Online Comment

Application H13-0728-26
Location Glebe House Church Street Moulton PE12 6NP
Proposal Proposed extension, garage conversion to provide living accommodation, demolition of existing outbuilding, erection of new outbuilding, removal of one site access & new boundary treatments including fencing - Approved under H13-0334-25. Modification of Condition 2 to allow amendments to previously approved plans

Name Imogen Colenutt, Assistant Conservation Officer
Address Council Offices The Hub Mareham Road LN9 6PH

Date Submitted 27-08-26
For/Against Comments

Ground Floor Plan as Proposed

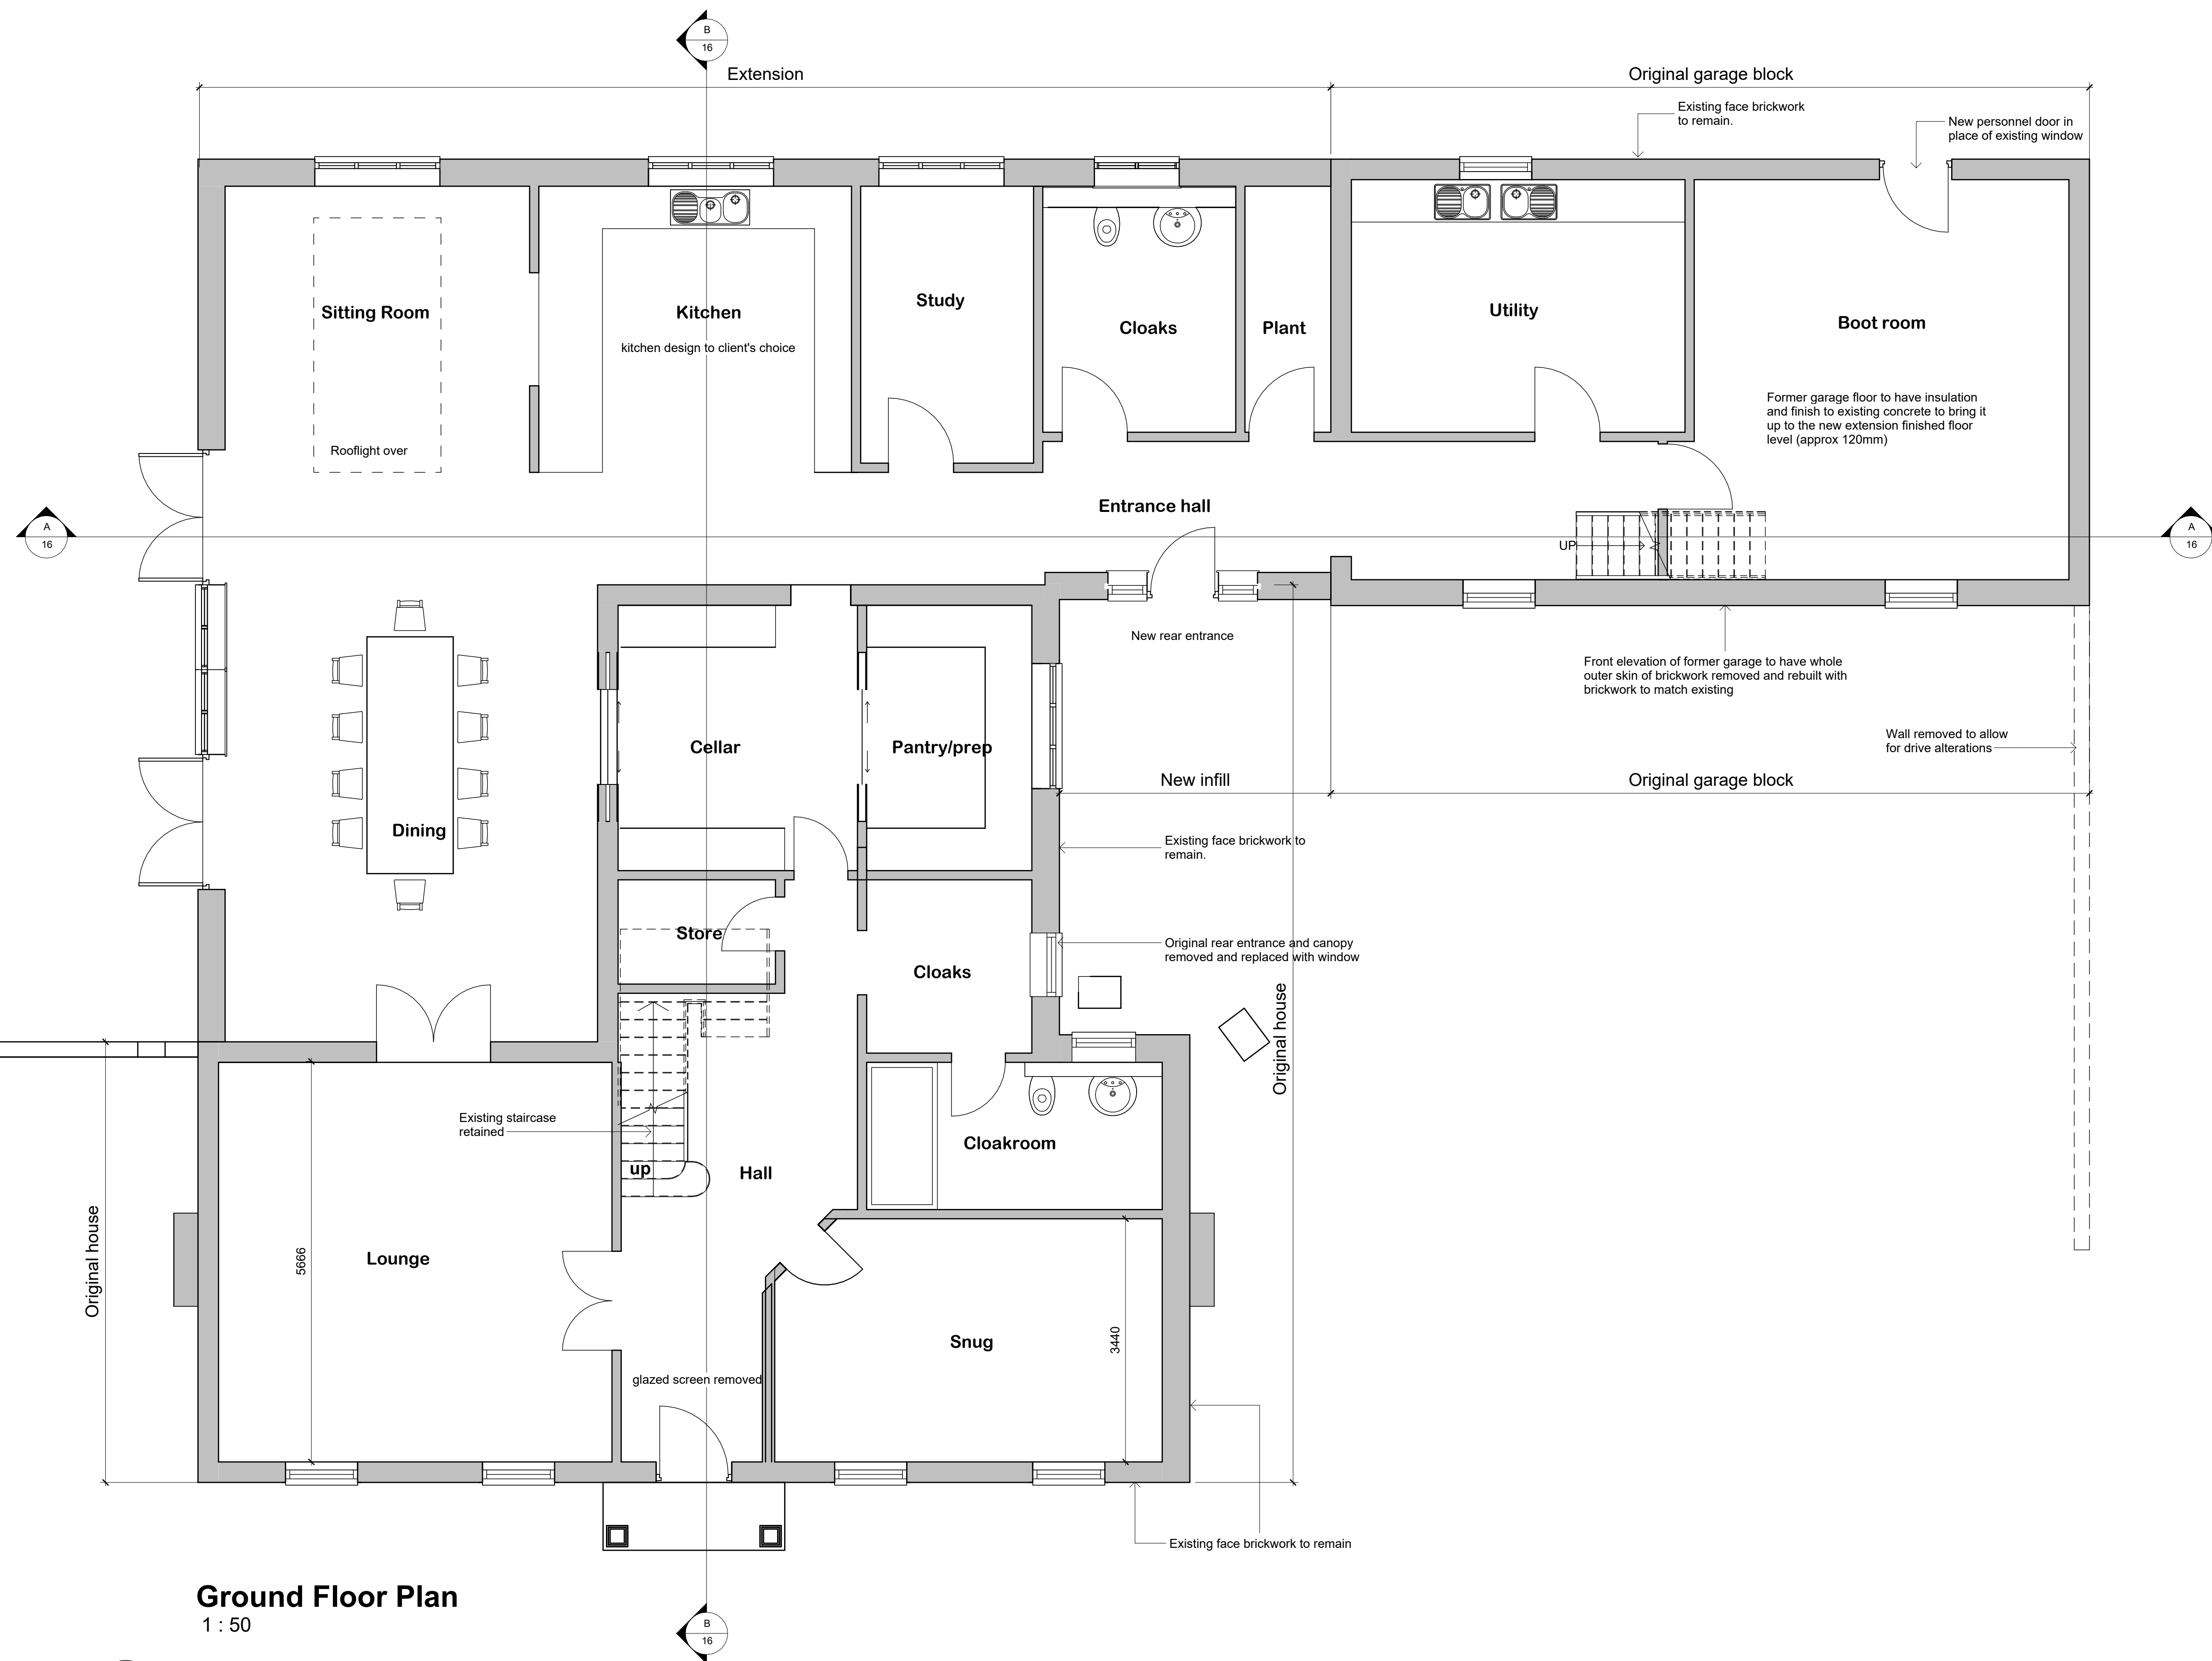
Do not support the proposed refacing of the garage block. The structure is clearly ancillary in nature and should continue to read as a garage building. The proposed alterations risk blurring this and is not reflective of its function.

Drawing Title:
Elevations as Proposed

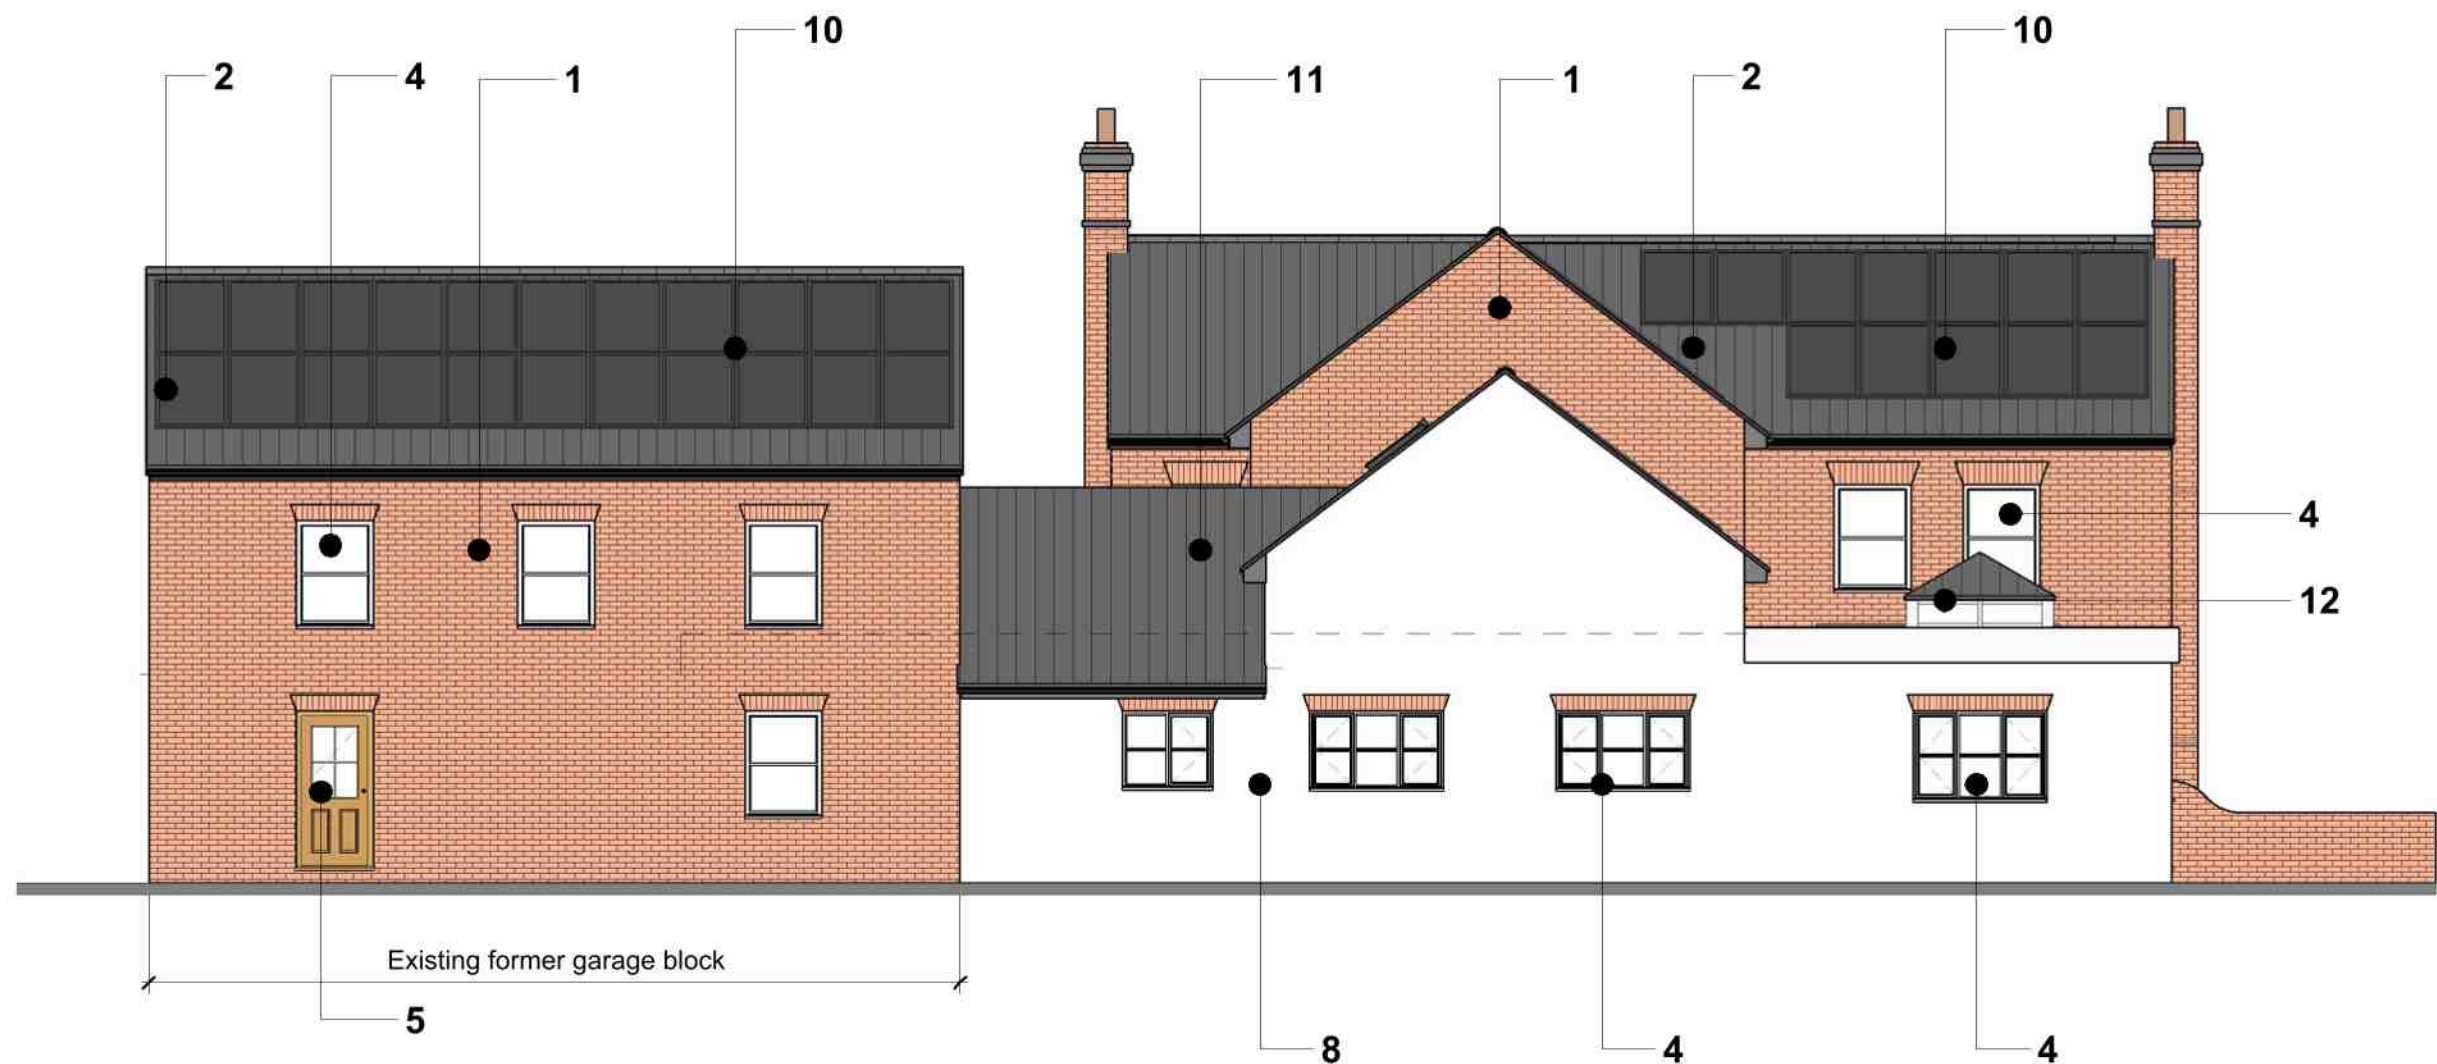
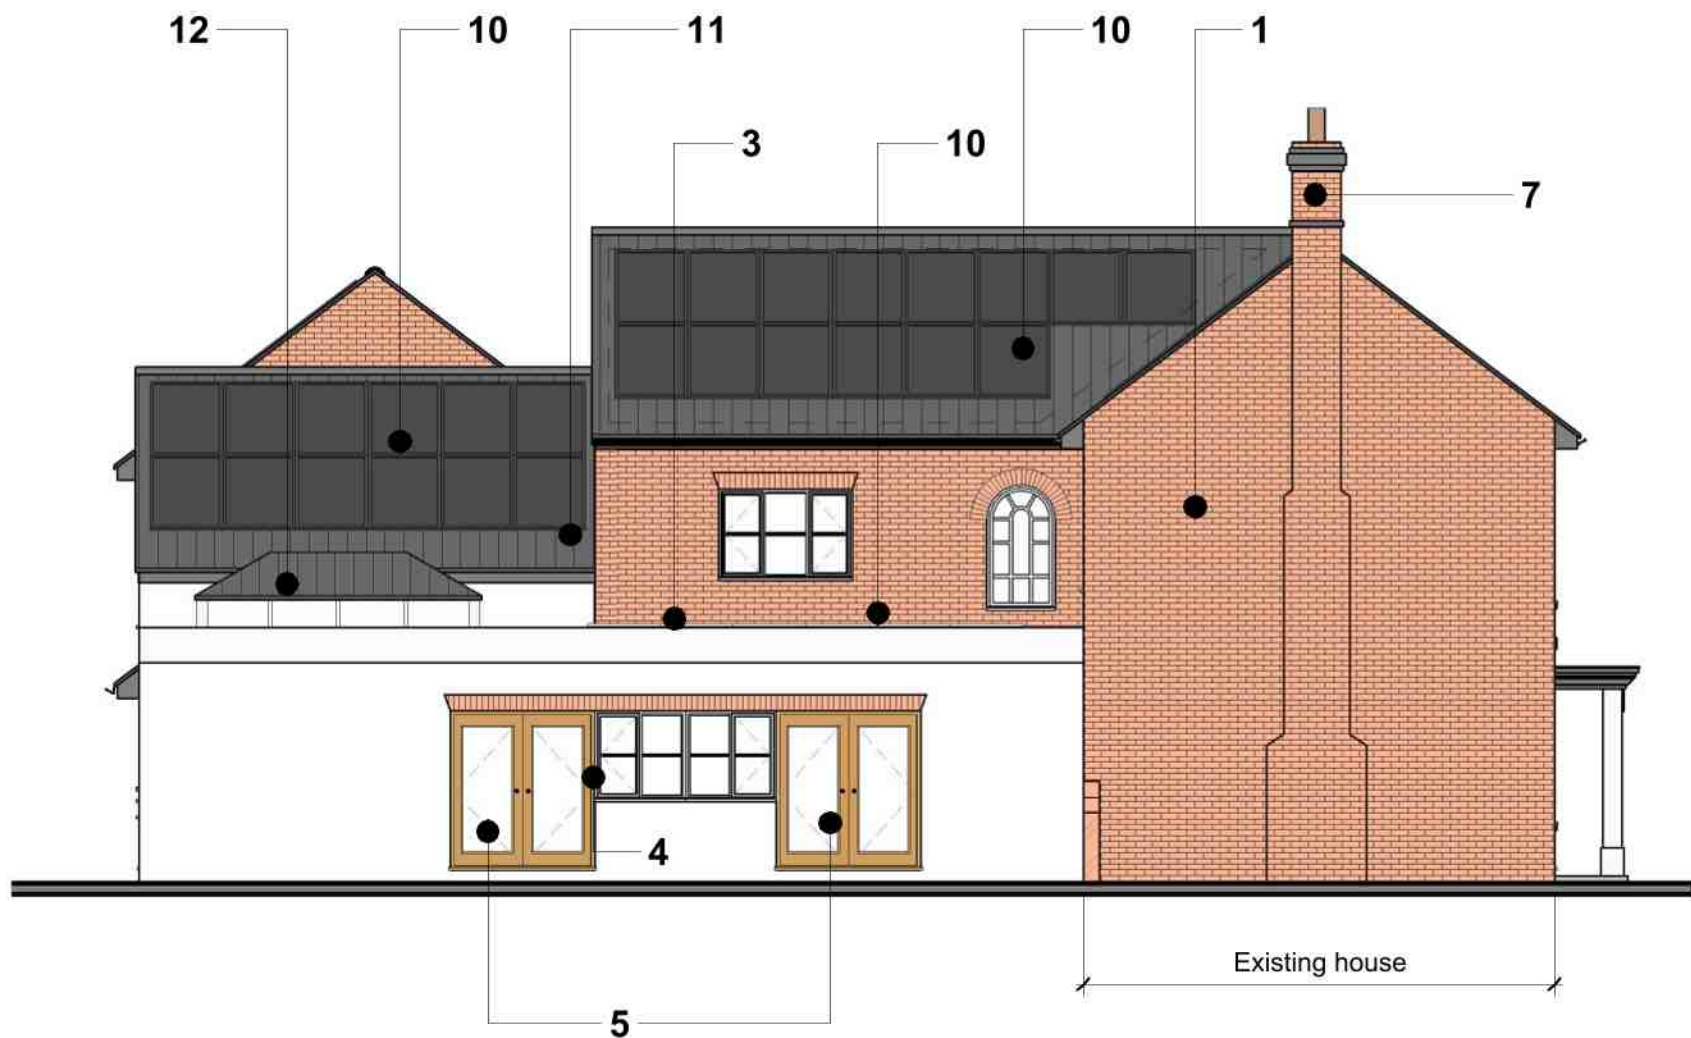
I also have concerns regarding the increase in height of the rear extension. Whilst the host building is modern and not itself a heritage asset, it has been designed in a way that sits comfortably within its setting and the character of the Conservation Area. Increasing the height of the extension, combined with the additional alterations proposed, risks making it more visible from the conservation area and the nearby listed building. This has the potential to draw greater attention to the extension and alter the way the building relates to its surroundings. This is amplified by the proposed use of render which would make the enlarged extension more visually prominent.
